From: Charlotte Burrows on behalf of Planning.Responses
Sent: 26 June 2013 09:29
To: Planning Scanning; Amanda Scholes
Subject: FW: old vicarage cottage

From: [REDACTED]
Sent: 25 June 2013 14:17
To: Planning.Responses
Subject: old vicarage cottage

MISS S POLLOCK
OLD VICARAGE COTTAGE
LYMINSTER
FENCE ELEVATIONS
SCALE 1-200

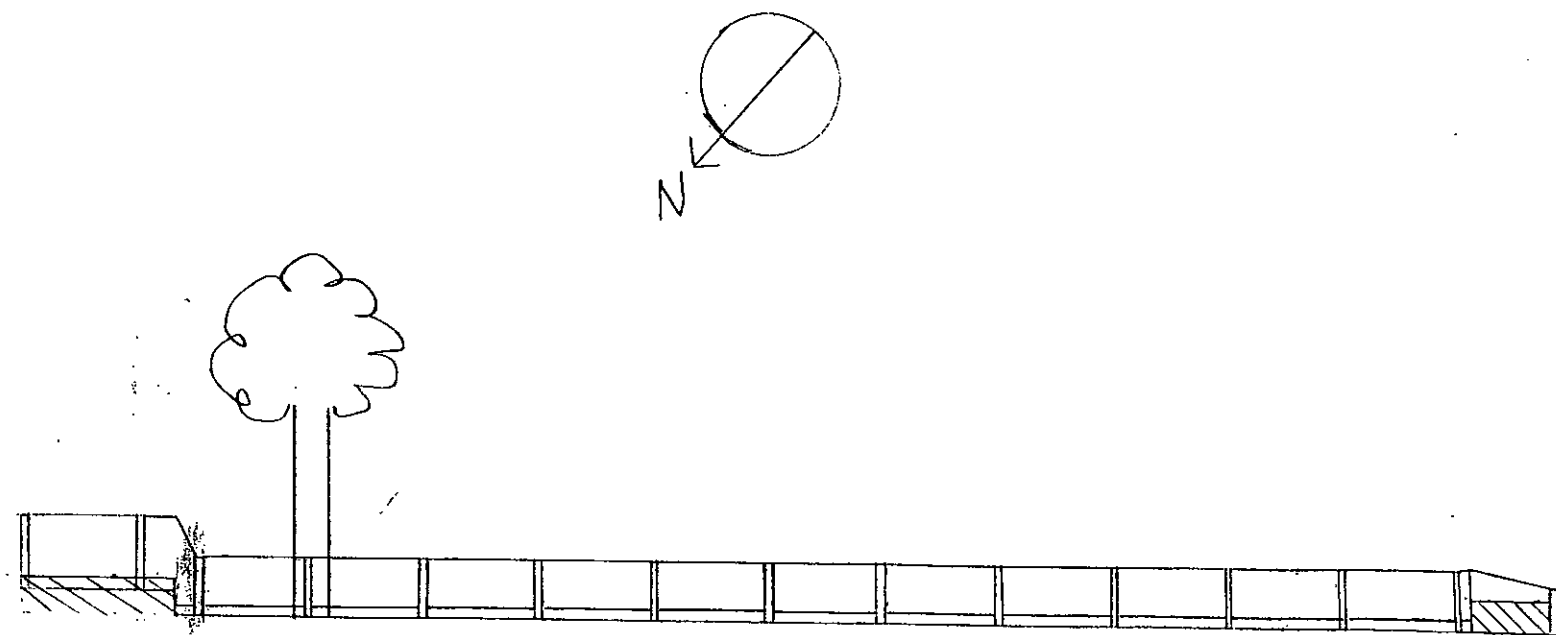
I am writing to object to the height and situation of the fence surrounding the above address. In my view it should be built on the inside of the flint wall and not be of such a height.

I understand their need for a fence or some construction to shield them from the lights of oncoming traffic, but this is in extreme. The flint wall is not something that should in my opinion be hidden behind a wooden fence.

I am writing to object to the fence which has been installed around Old Vicarage Cottage. No one would object to someone erecting a fence per se, but it is outside the of the beautiful old flint wall which runs alongside the road. If they erected the fence inside the wall and made it less high it would be acceptable,
